Cambridgeshire County Council and Fenland District Council

Relevant Representations

- 1.1 On 15 November 2022, Cambridgeshire County Council (CCC) submitted their Relevant Representation to the Planning Inspectorate (PINS) jointly with Fenland District Council (FDC) in respect of the application for a Development Consent Order (DCO) submitted by Medworth CHP Limited for a Combined Heat and Power (Energy from Waste) Facility.

- Notes:
1. Proposed visibility based on New Bridge Lane being subject to a revised 30mph speed limit.
  2. New street lighting has been provided on an indicative basis (at 30m intervals and at conflict areas) and will require detailed design and assessment.

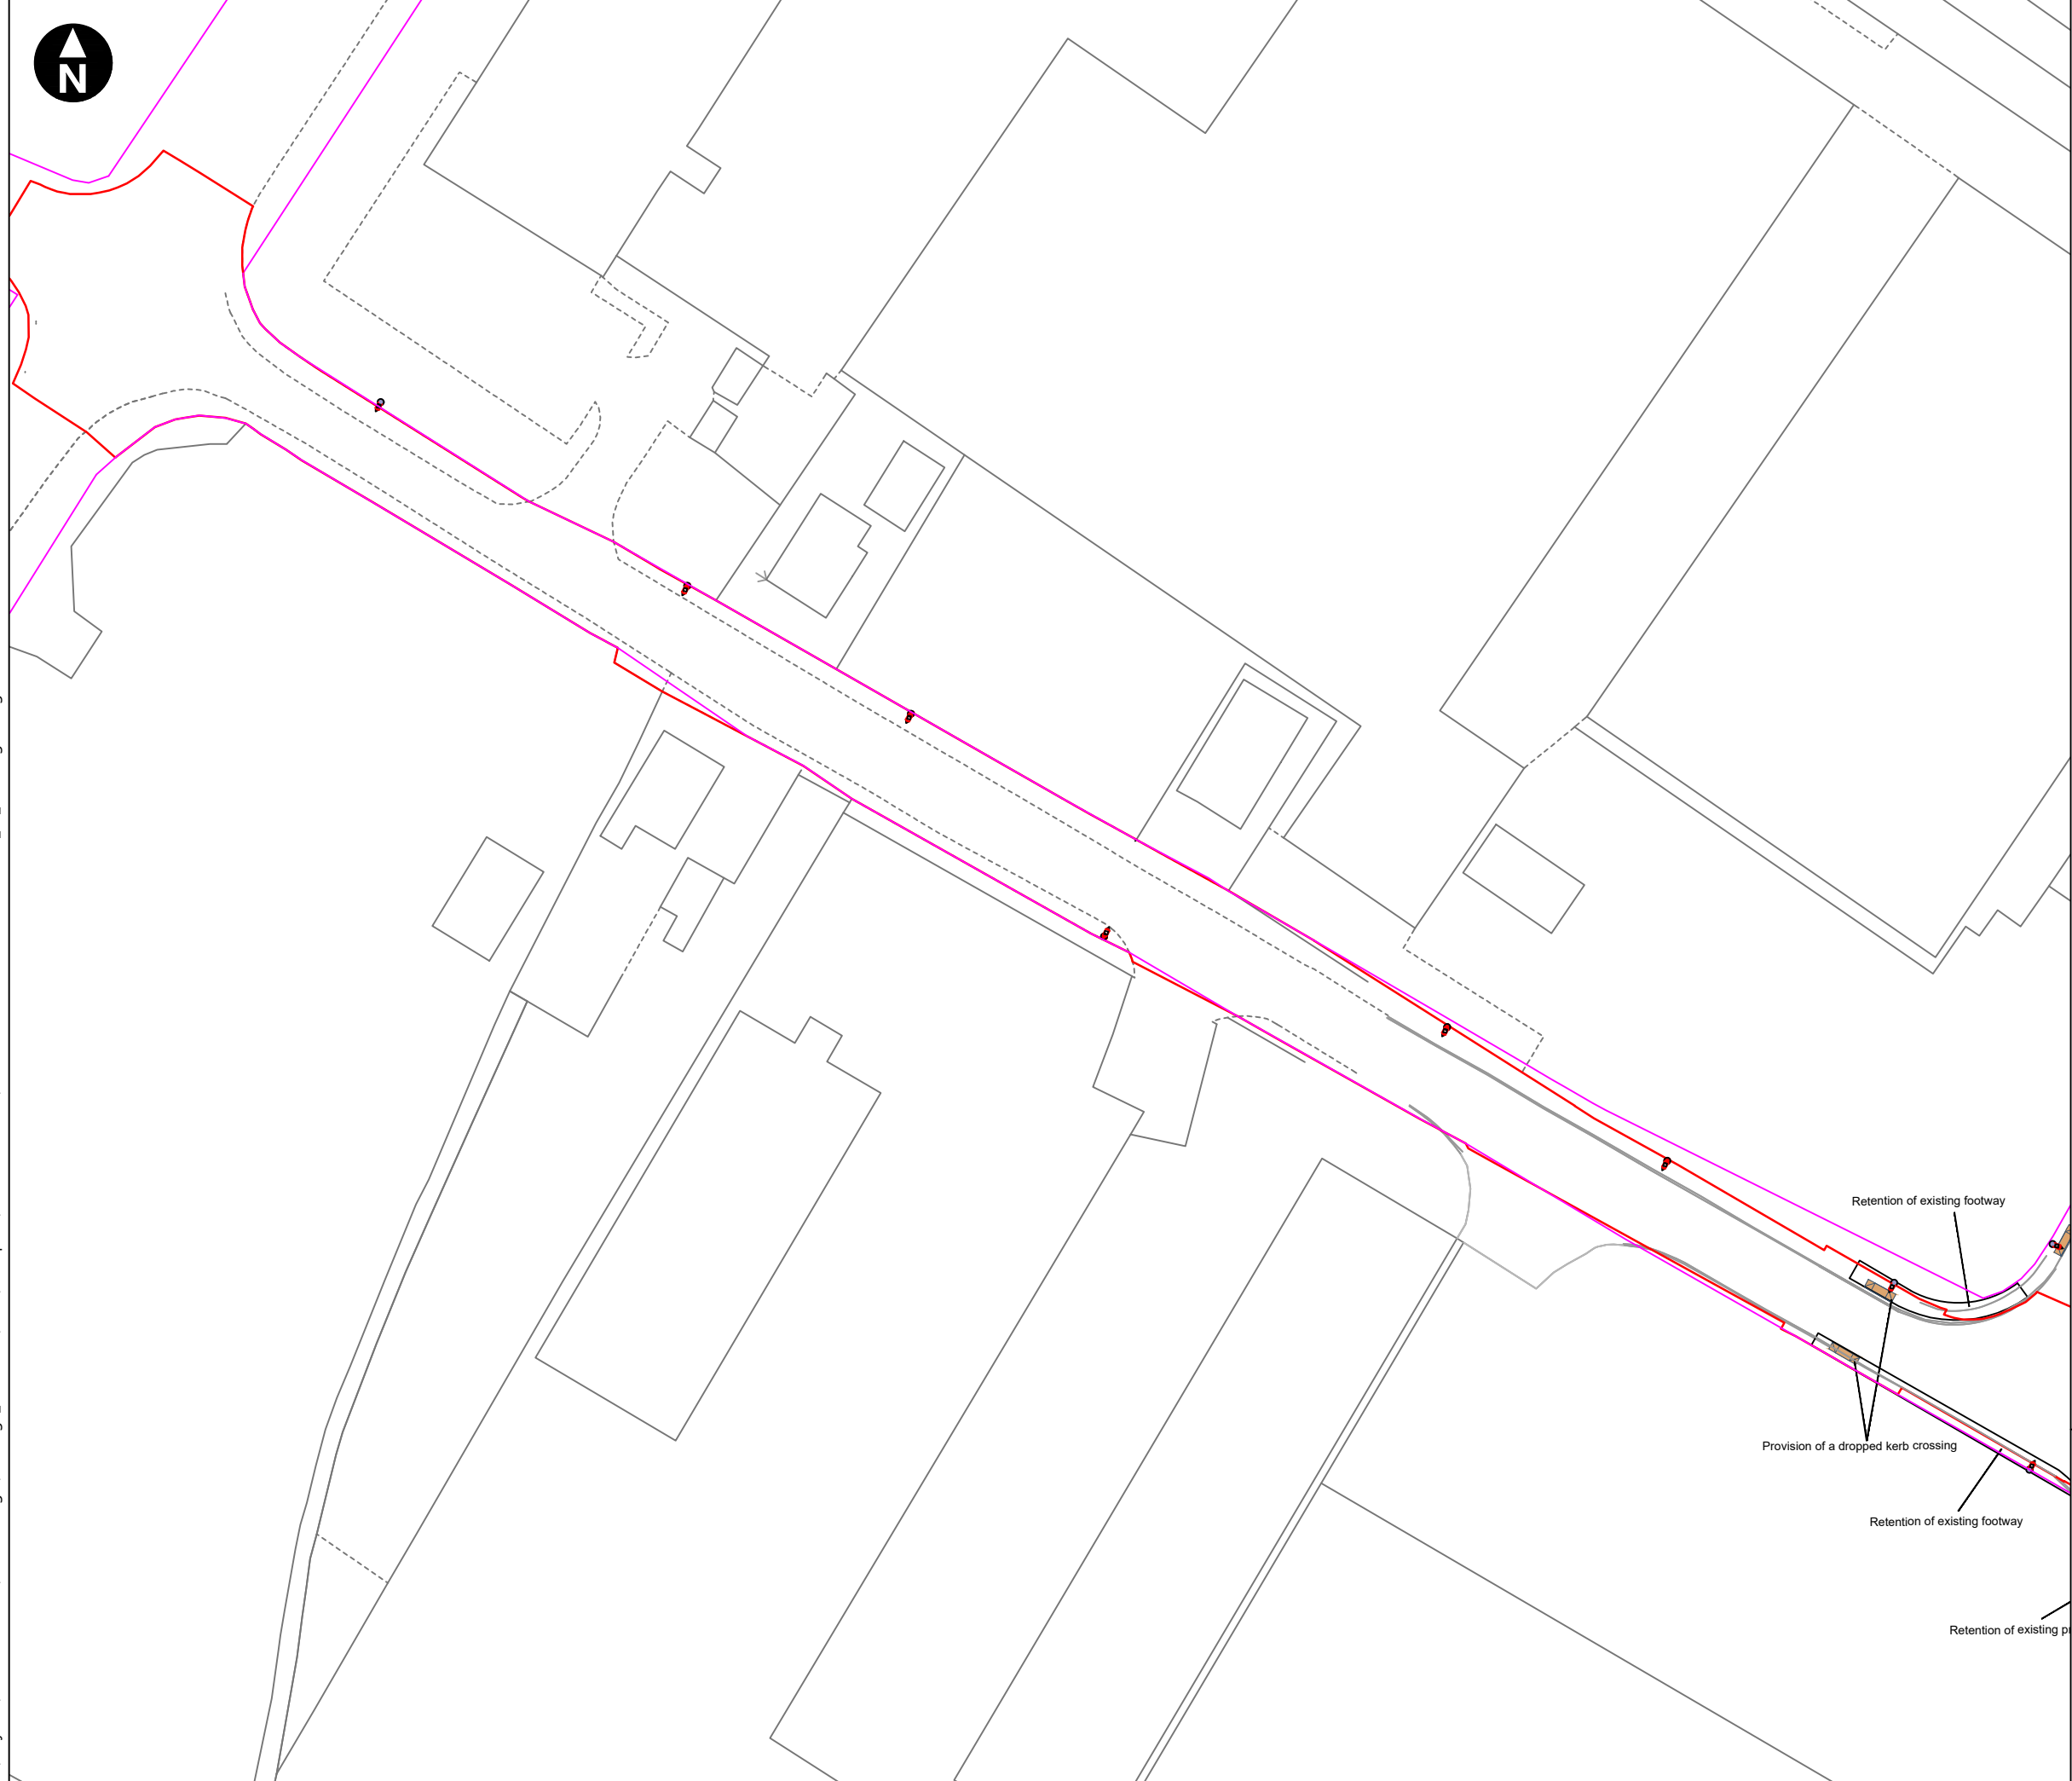
- 3.7 New accesses A3, A4 and A5 are to be maintained at public expense. This is unacceptable to CCC as these accesses are not connected to any publicly maintainable highways.

**Figure 10.1iv**  
**Cromwell Road/New Bridge Lane Signal Scheme - General arrangement**

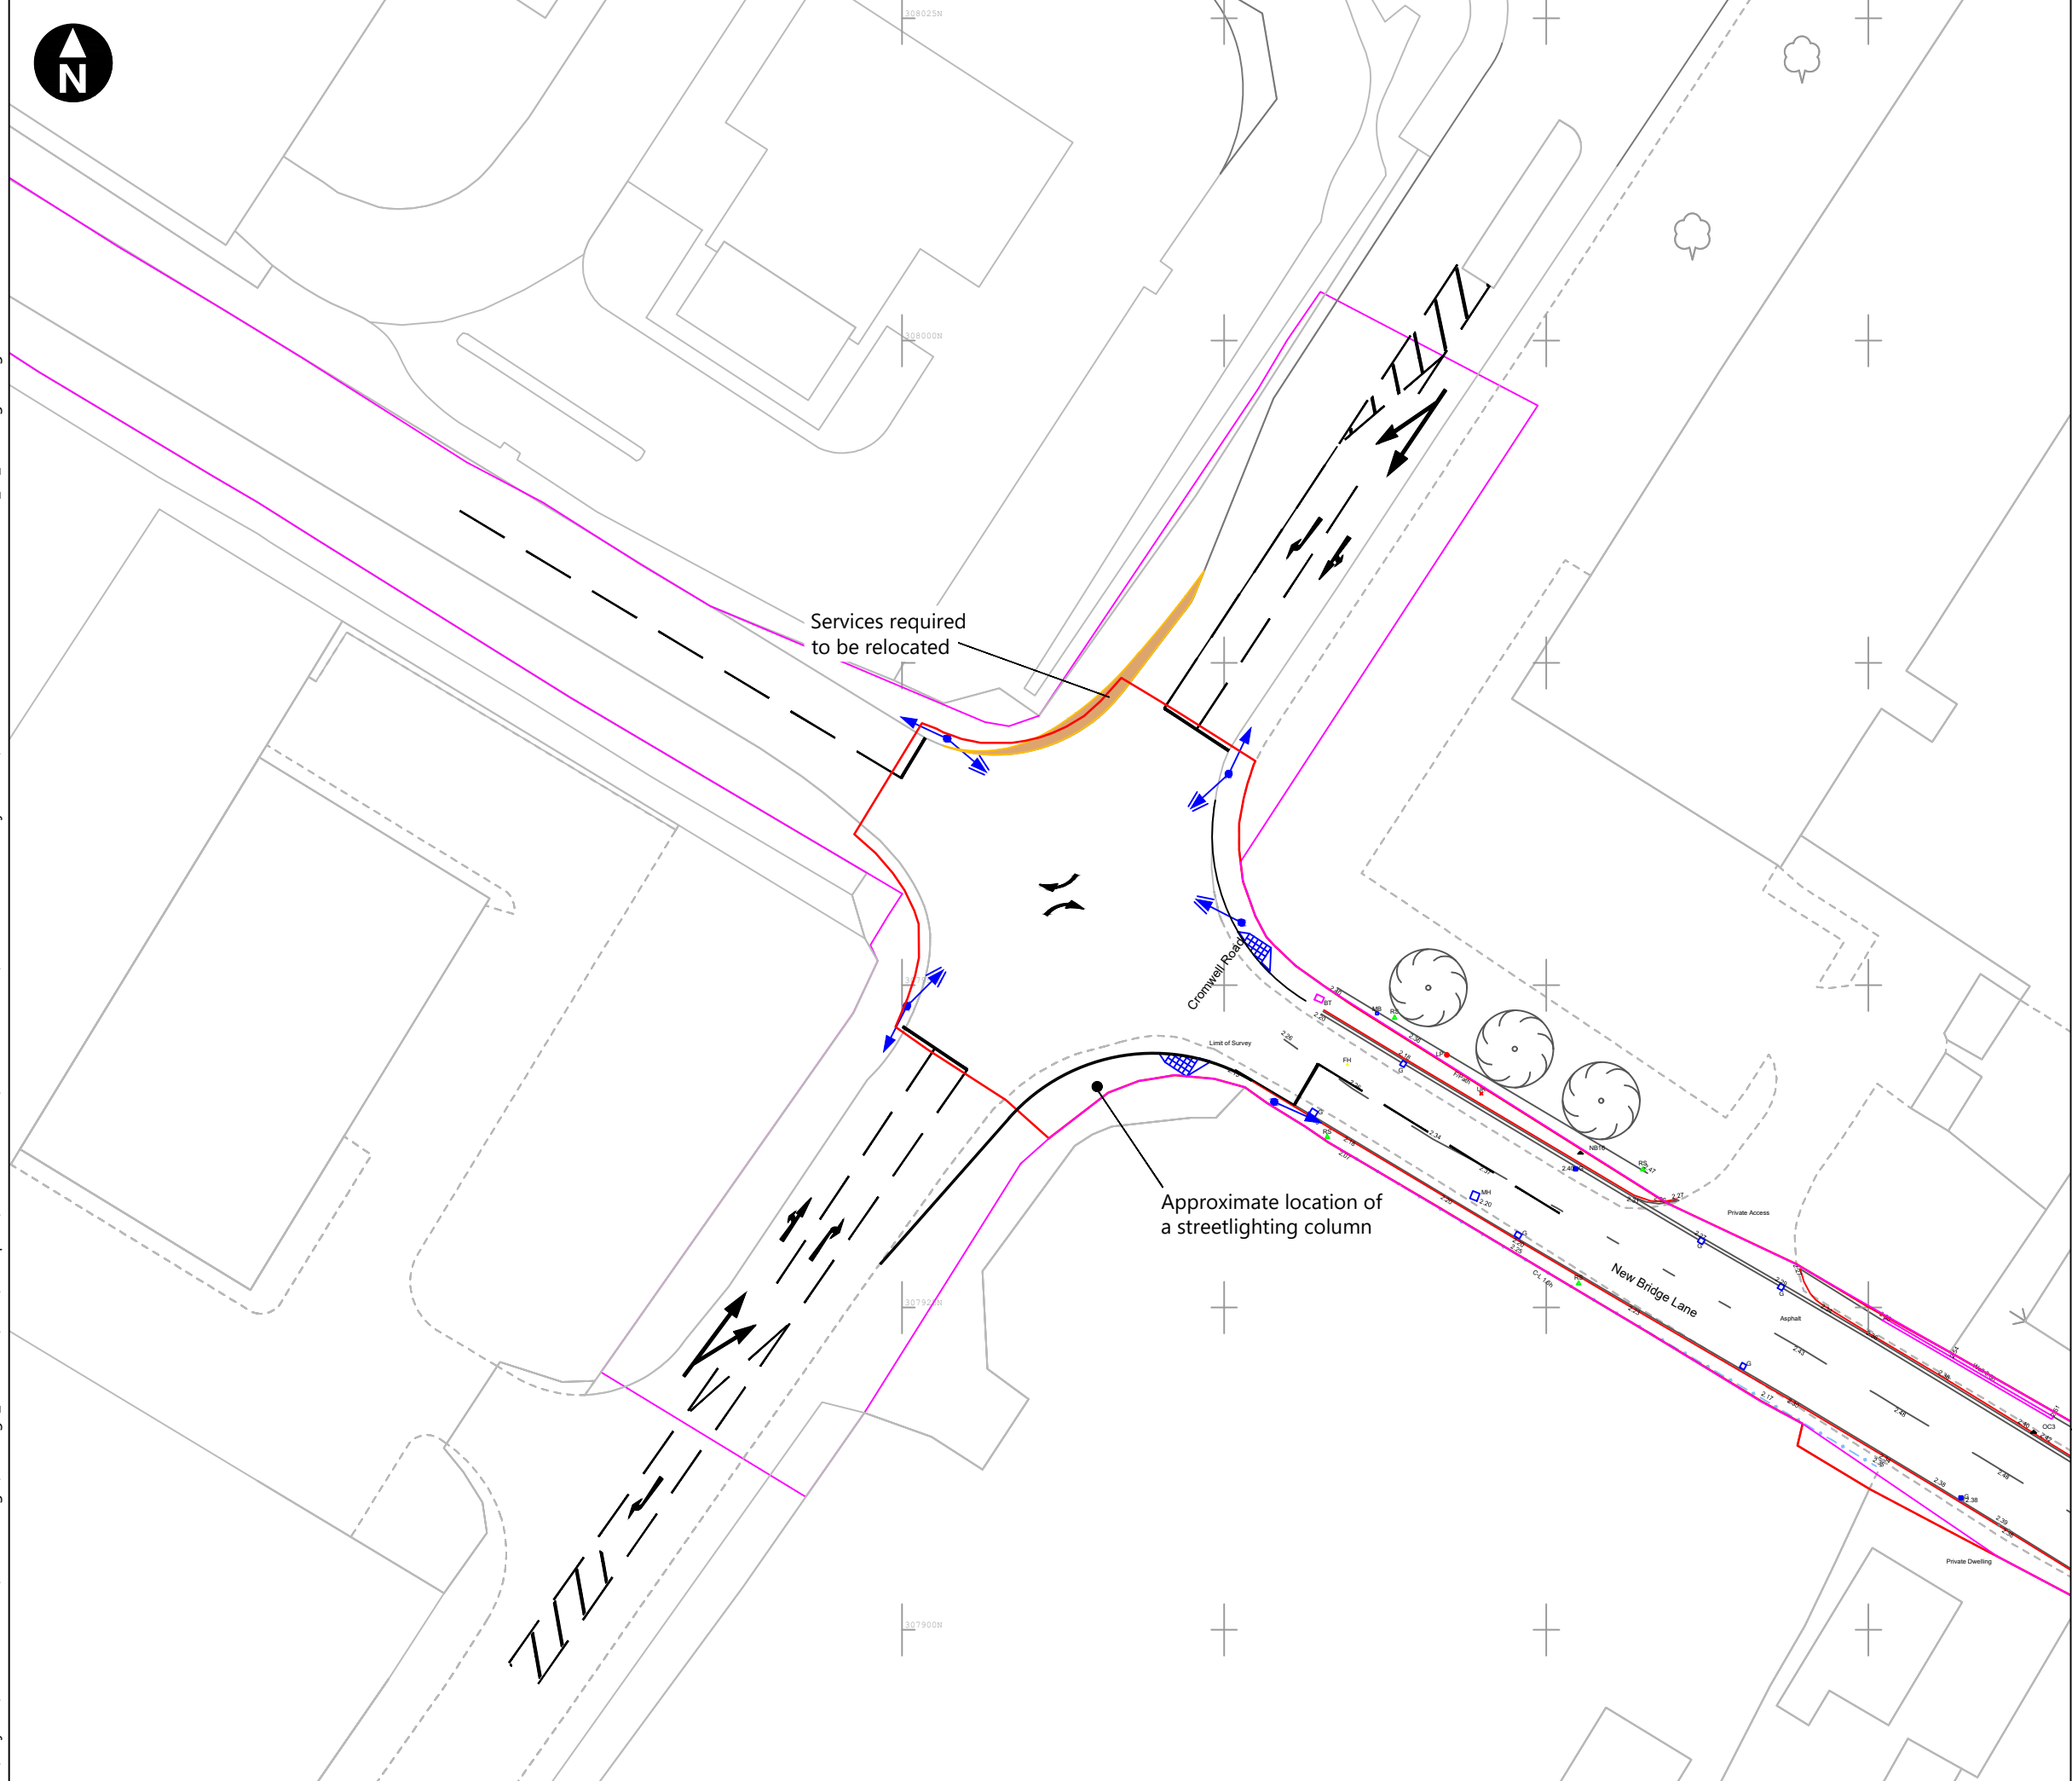
- 3.8 The increase in slow moving right turning HGV vehicles at Cromwell Road / New Bridge Lane roundabout could cause capacity and safety issues at the junction. The applicant should be required to signalise the junction to reduce the risk of localised issues.
